**Planning Department
Transportation Development Services Section**

Re: Certification Submittal for Final Building Certificate of Occupancy for
Charter Bank Addition & Interior Remodel, [H-21 / D15]
2130 Eubank Blvd NE
Architect's Stamp Dated 02/27/07

Re: Certification Submittal for Final Building Certificate of Occupancy for
Charter Bank, [H-21 / D15]
2130 Eubank NE
Architect's Stamp Dated 02/07/07

**Re: Charter Bank Addition / Remodel, 2130 Eubank Blvd NE, Grading and
Drainage Plan**

SHEET NUMBER
C-102

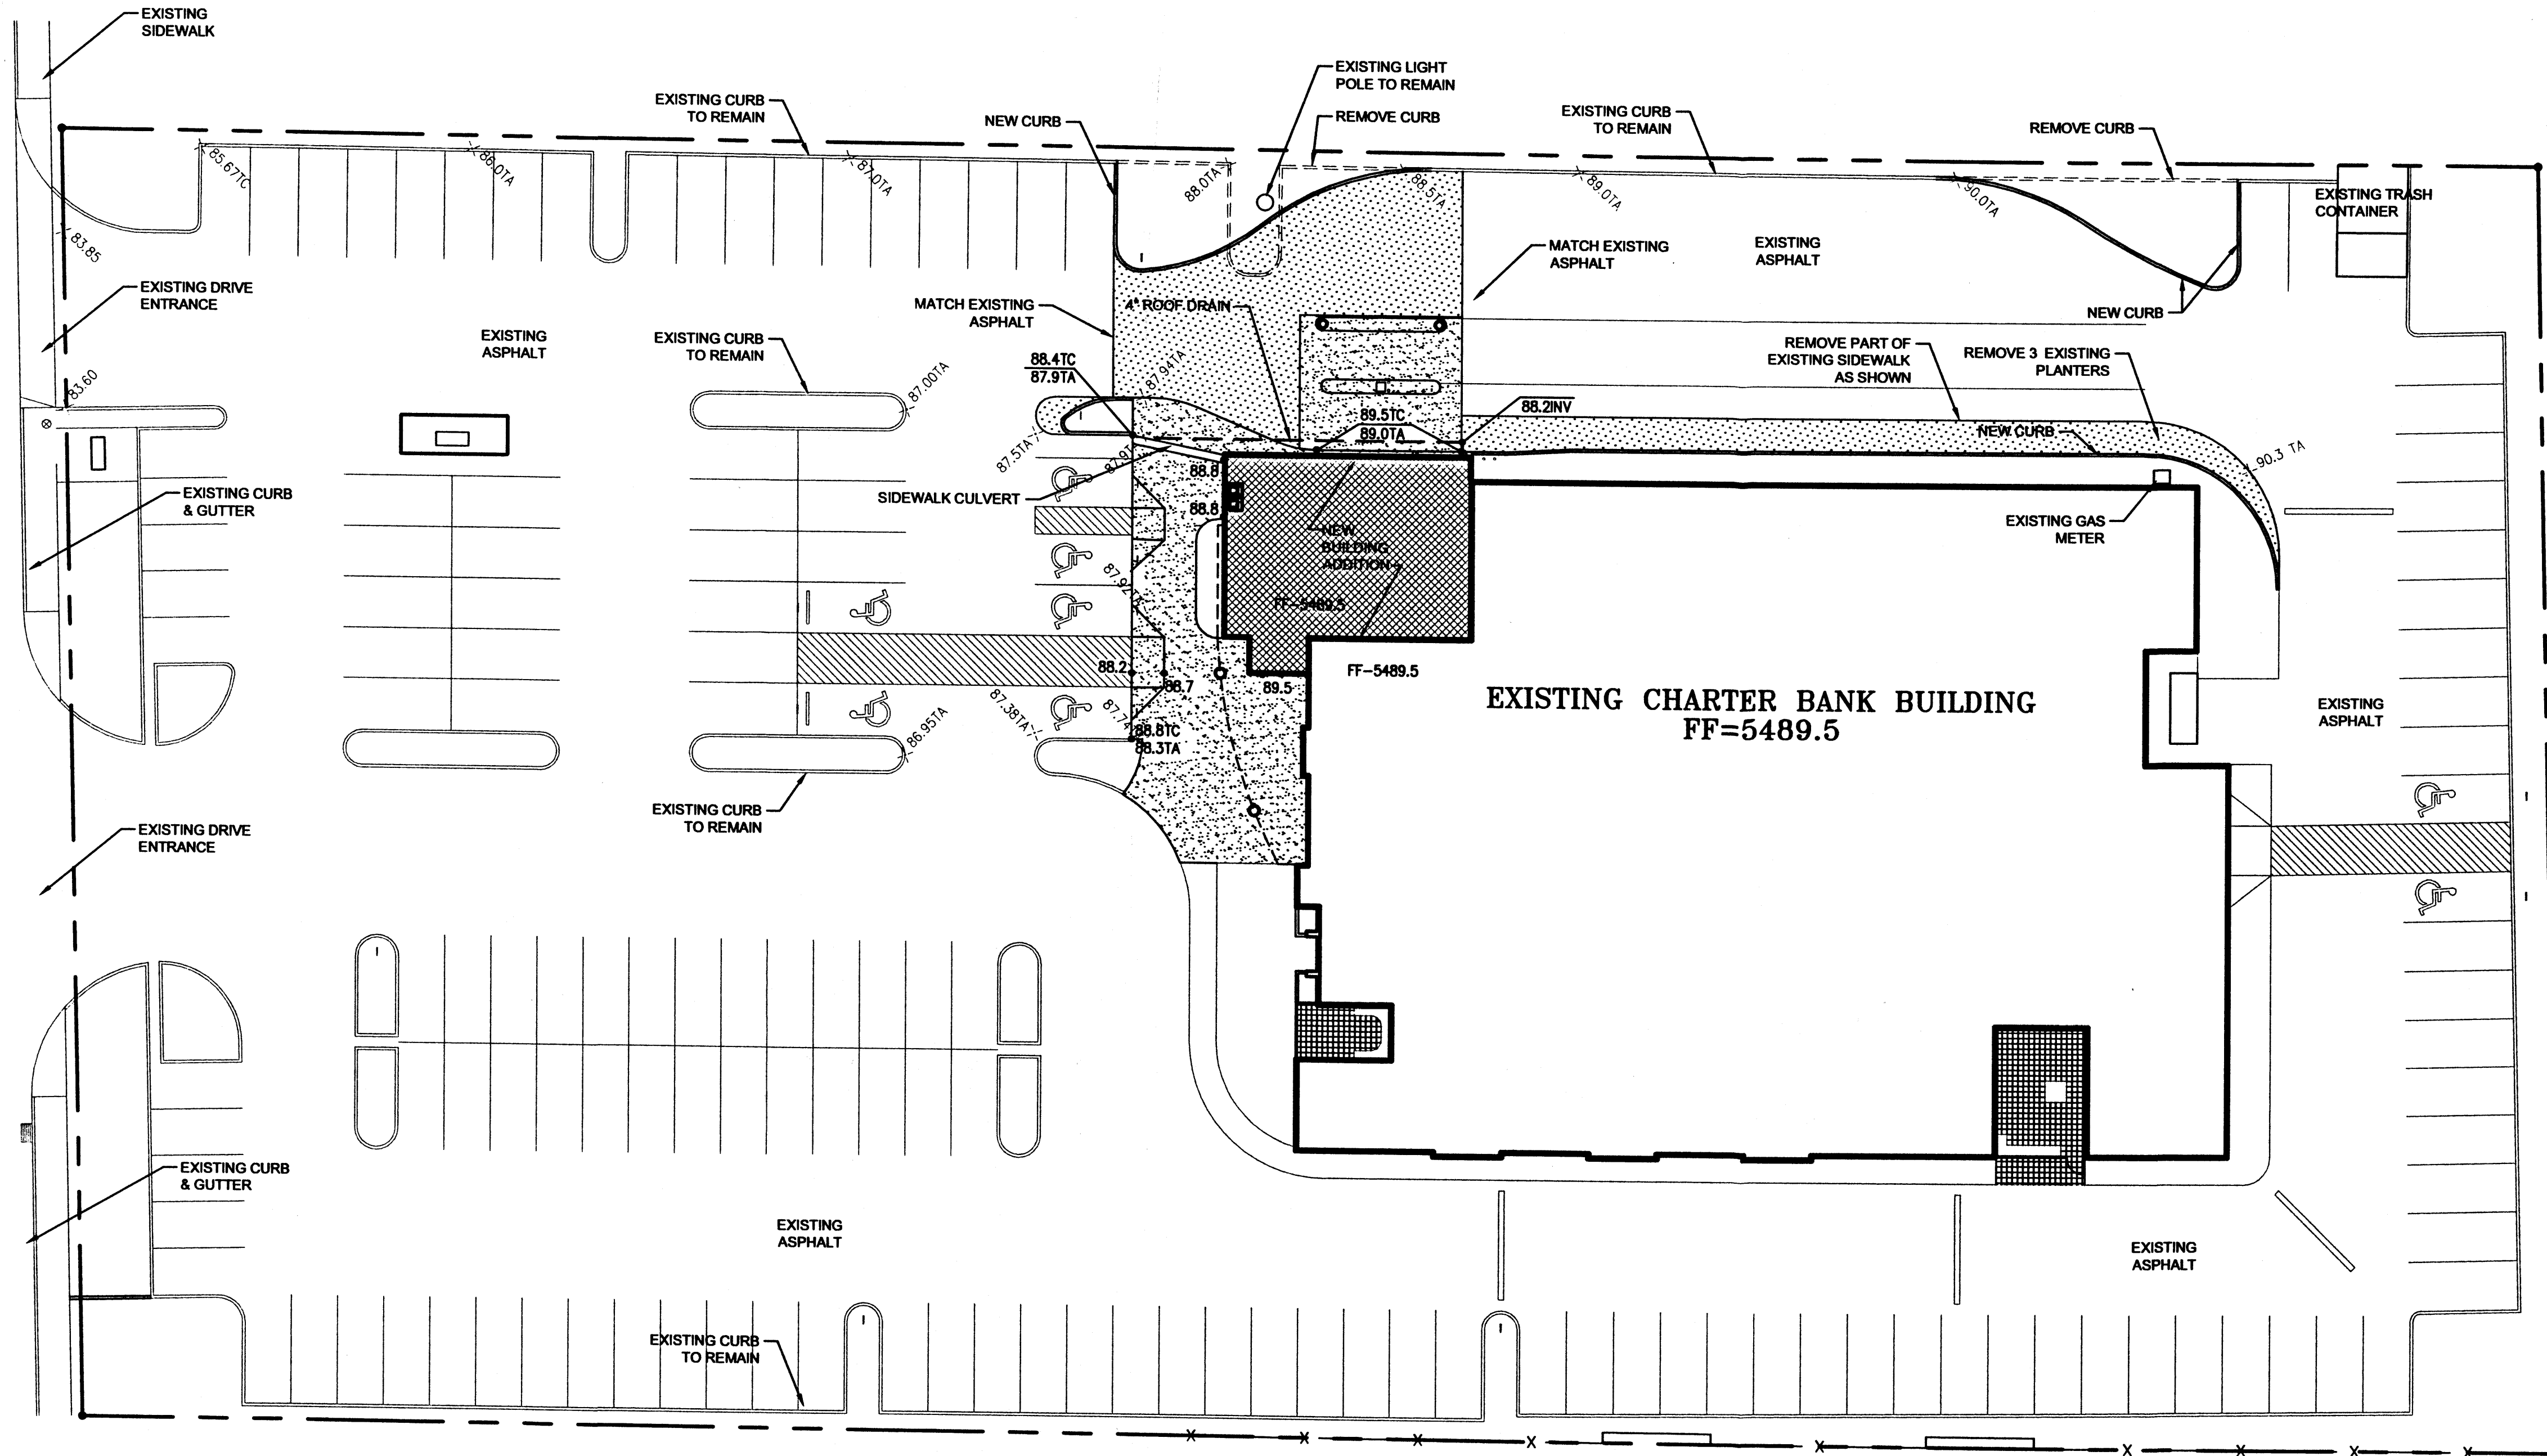
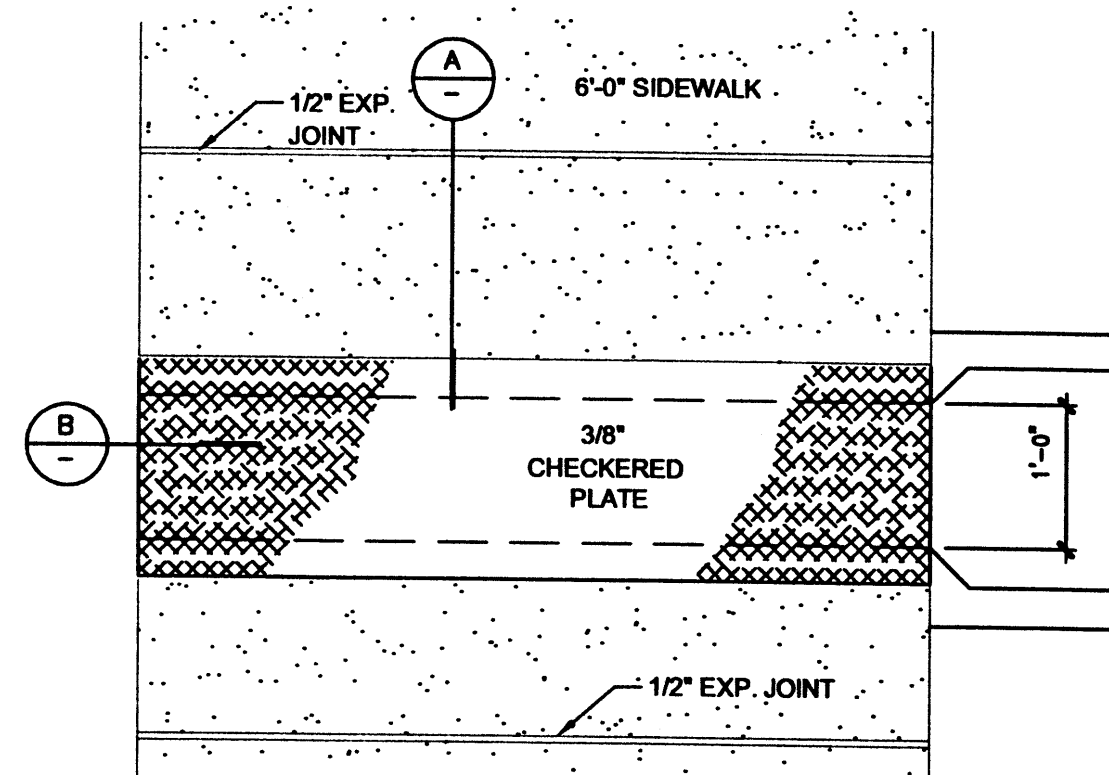
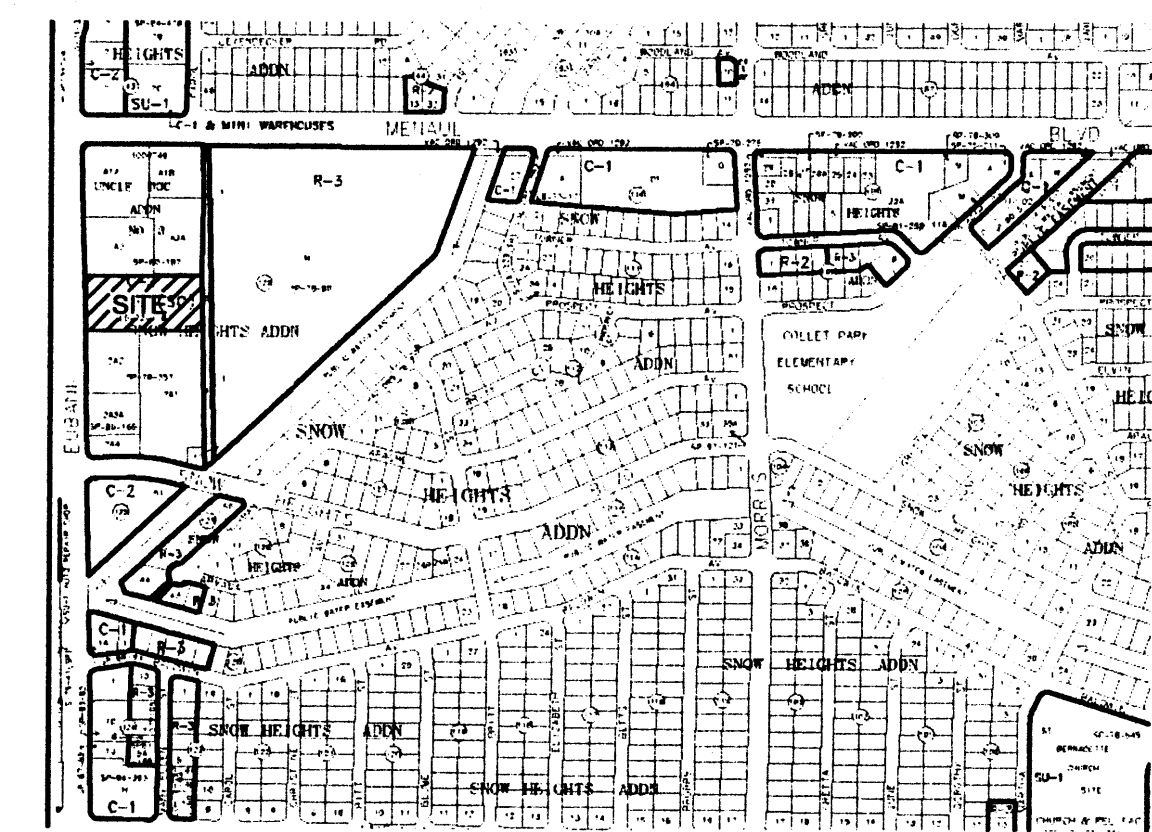
What is the total lot area?

Why are the proposed flow rates $<$ existing
if some landscaping is removed?

Clarify existing flow

SHEET NUMBER
A-101

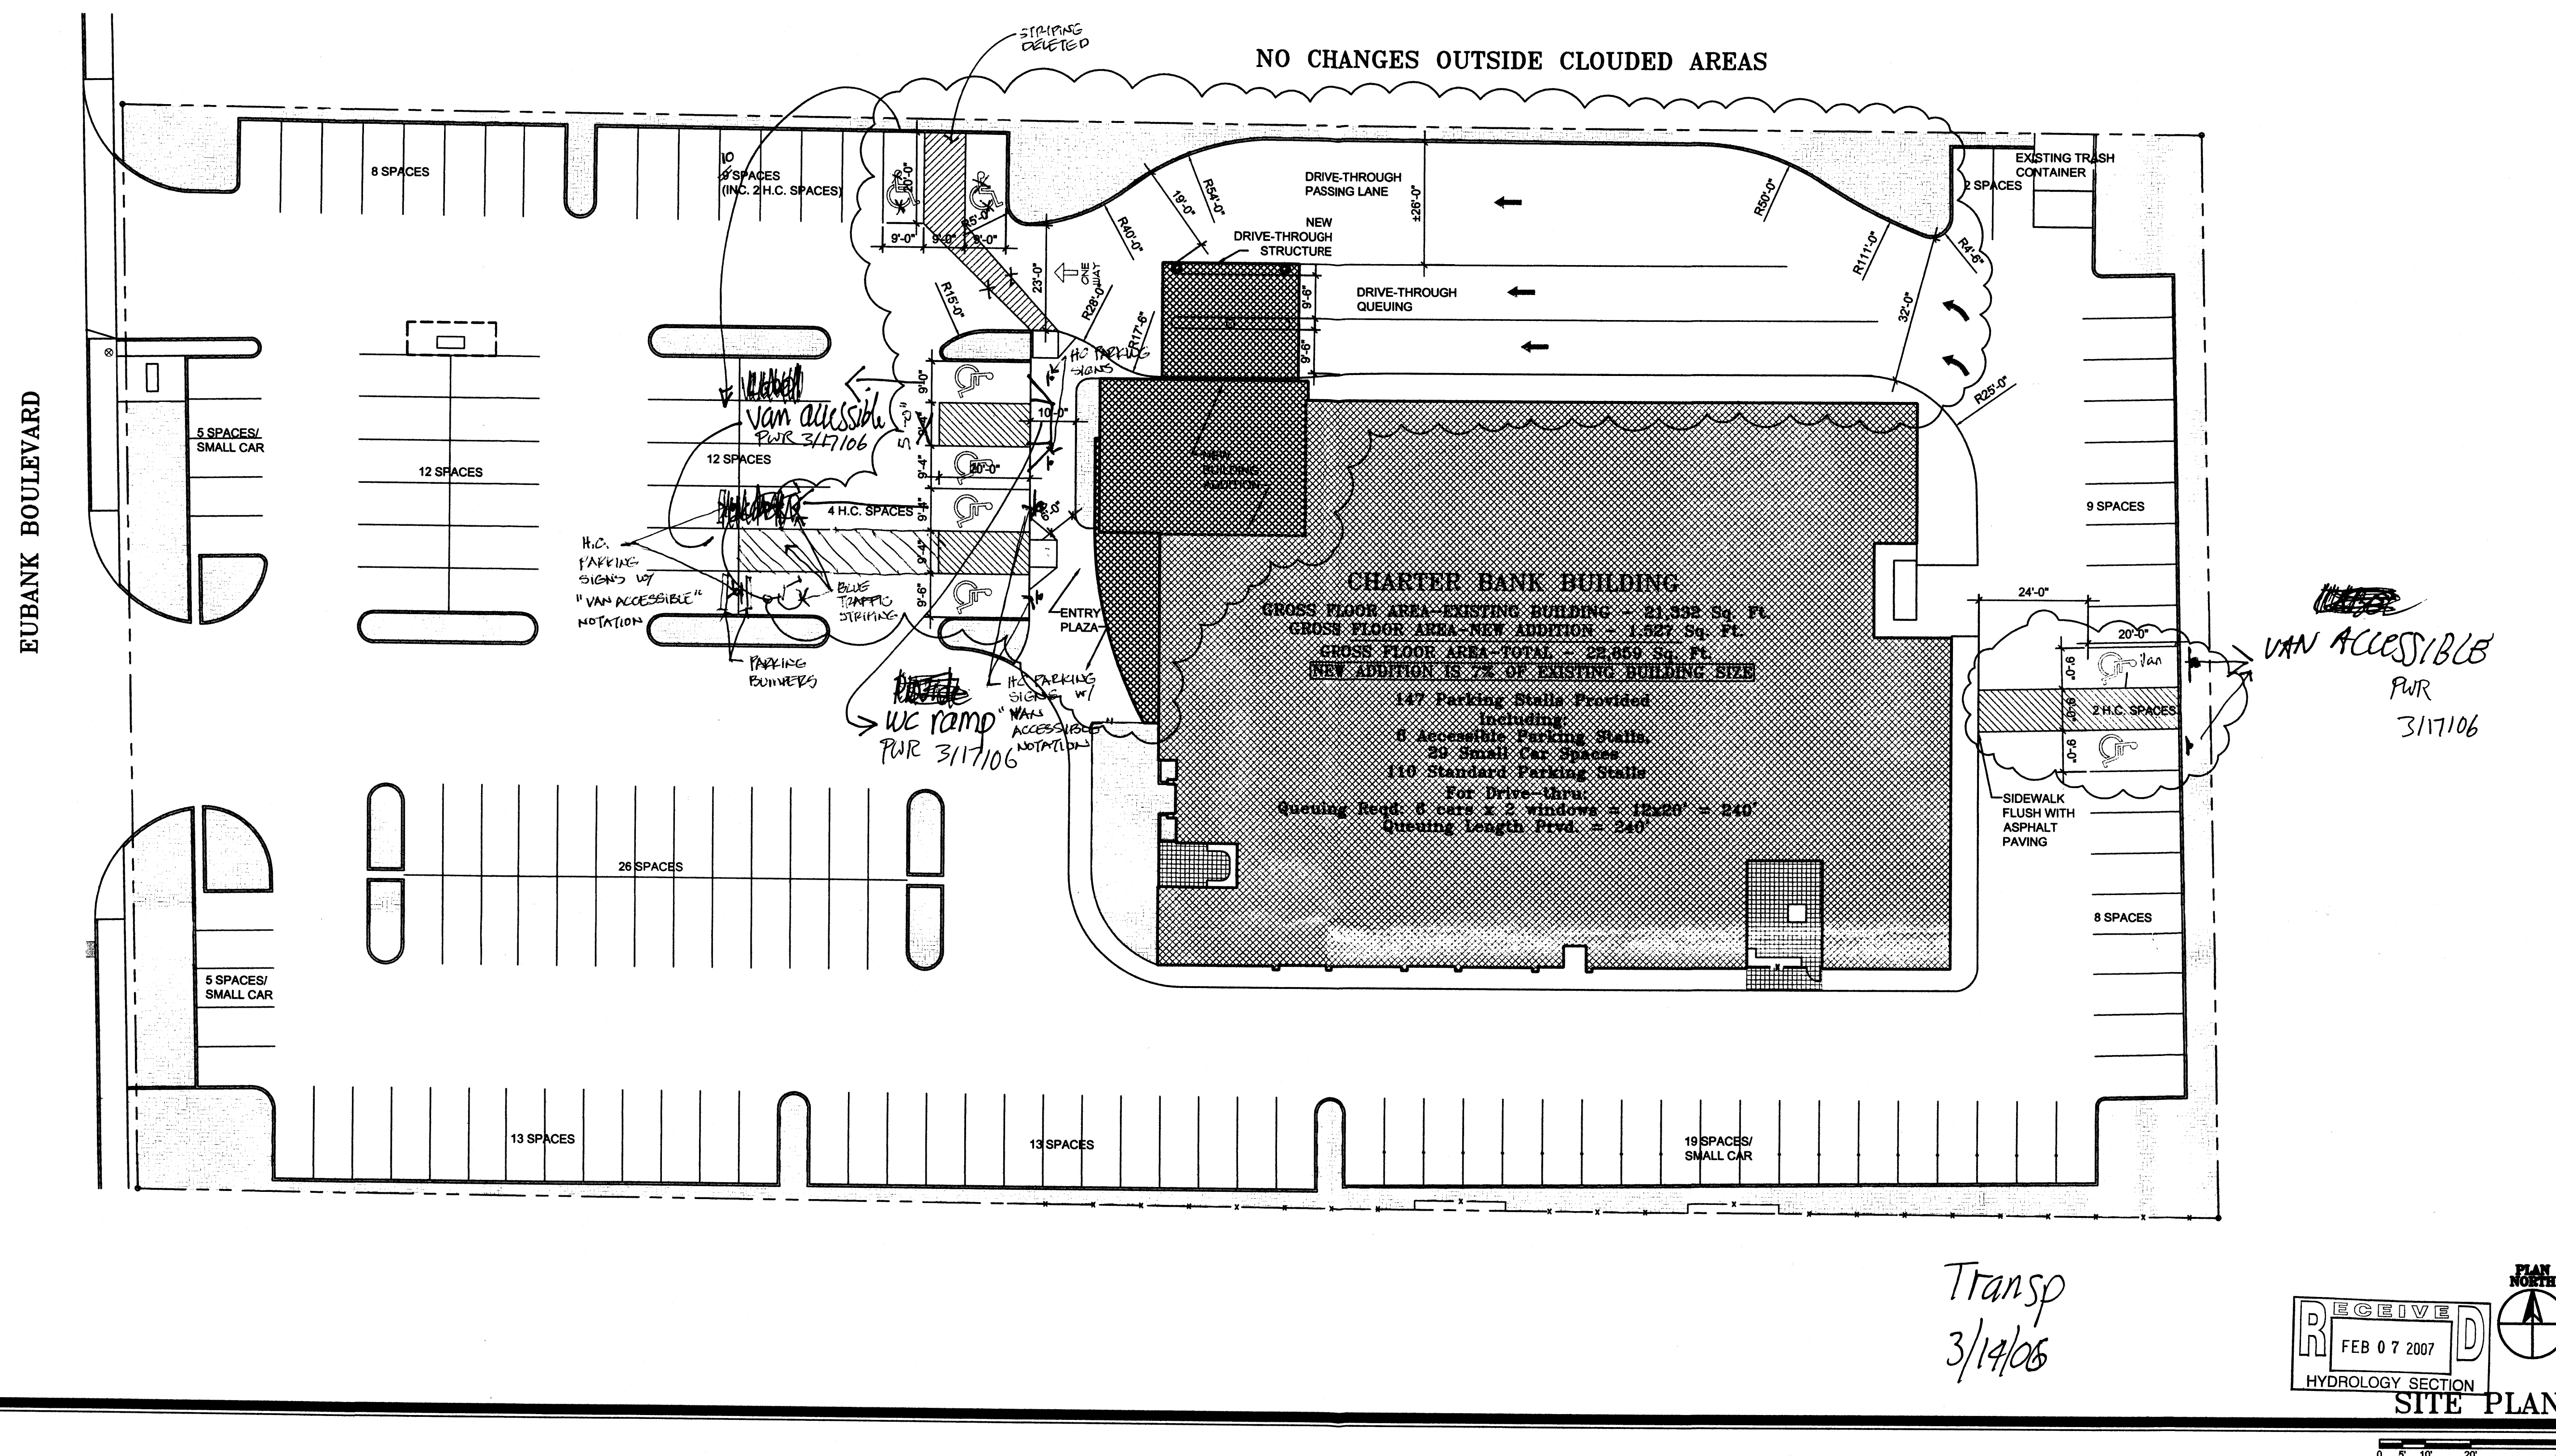
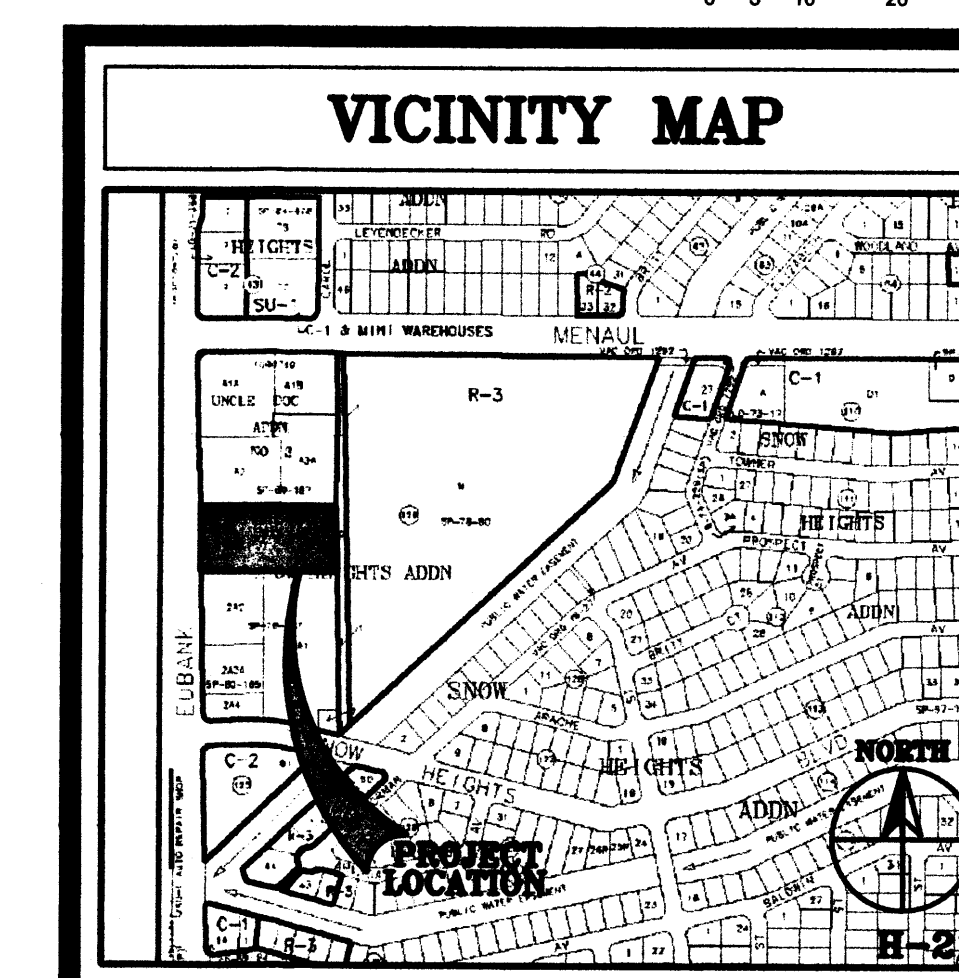
The TCL / Letter of Certification submitted on February 7, 2007 is not sufficient for acceptance by this office for final Certificate of Occupancy (C.O.). A 30 day temporary CO will be issued to address the following: **The TCL (or DRB Site Plan) submitted for Final C.O. needs to be the exact copy of the approved TCL in the plan set approved for building permit.** This will be the latest edition, which may have redlined comments, initialled and dated by the designer-of-record.
